From: Anita Gardner
Sent: 28 April 2021 19:32

Subject: AB/22/21/HH and AB/23/21/L - 17 Maltravers Street

Proposed Works at 17 Maltravers St. ARUNDEL BN18 9AP	
Site Plan.	2
1:200 Feb'21

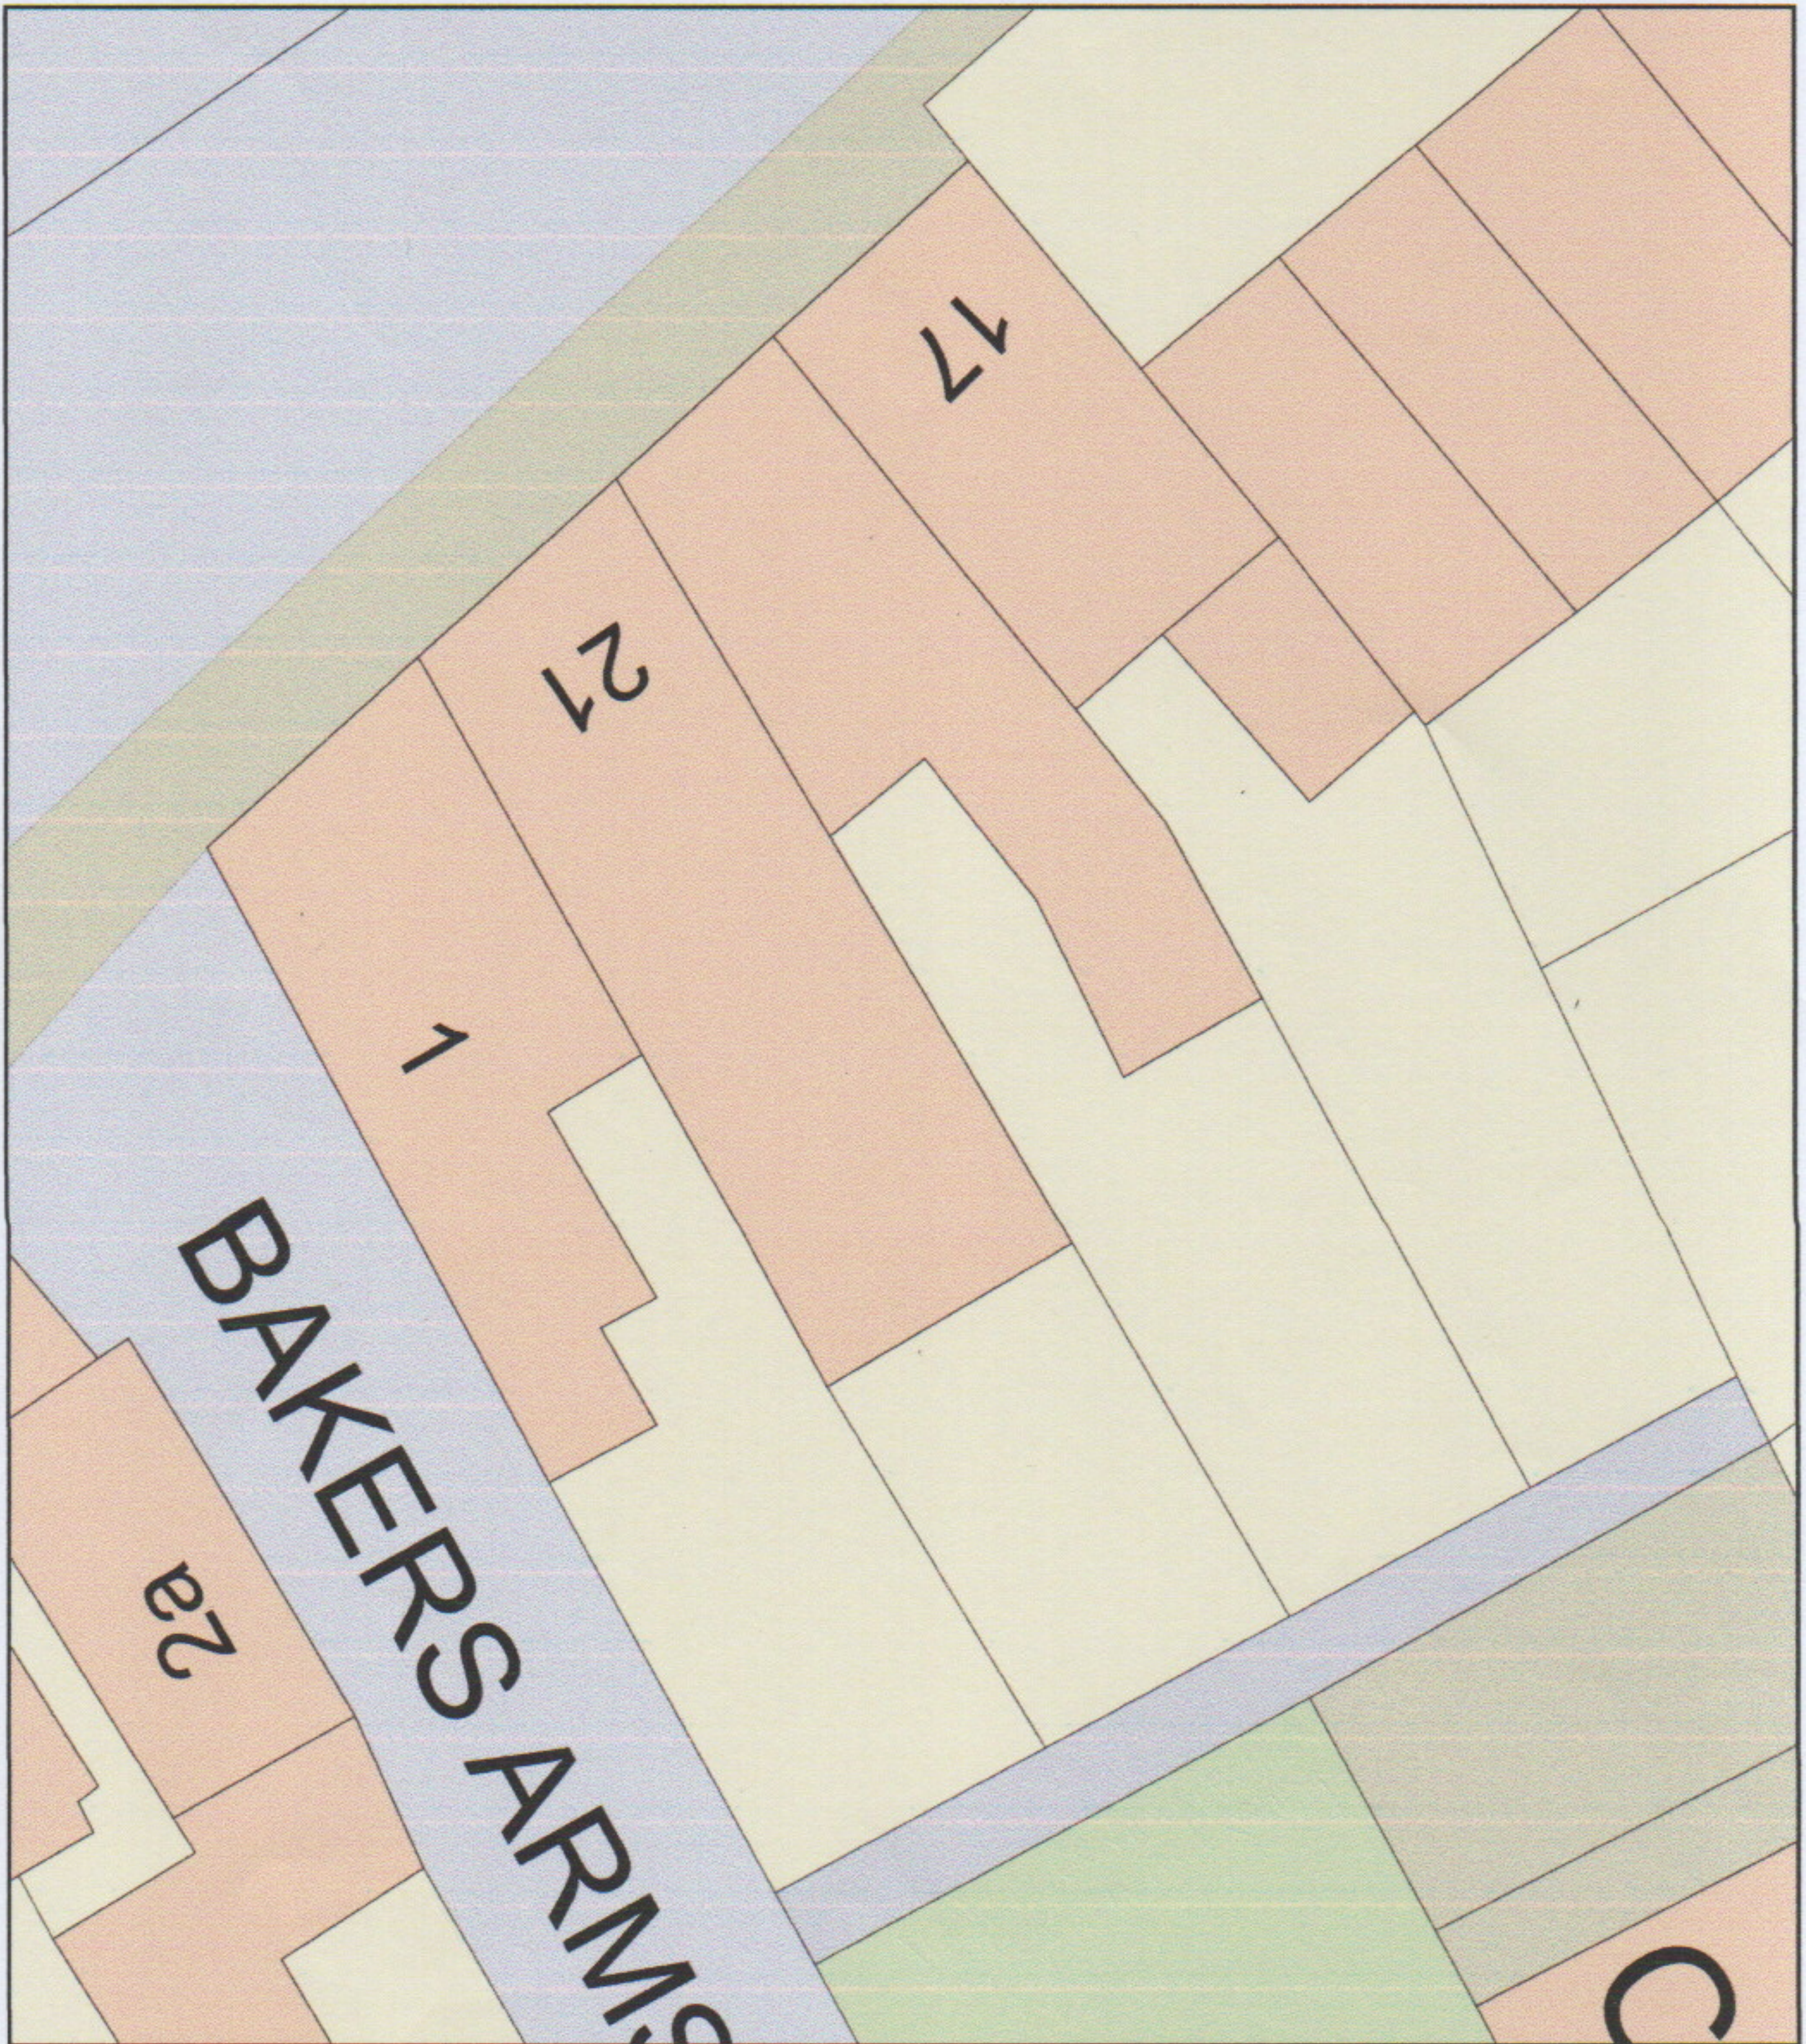
I have started looking at the above applications in detail and it is not clear from the block plan where the proposed rear porch extension is located. Please can you provide an updated block plan to clarify the extent of the extension. I would also appreciate a cross section detail of the proposed rooflight to ensure no adverse overlooking would result.
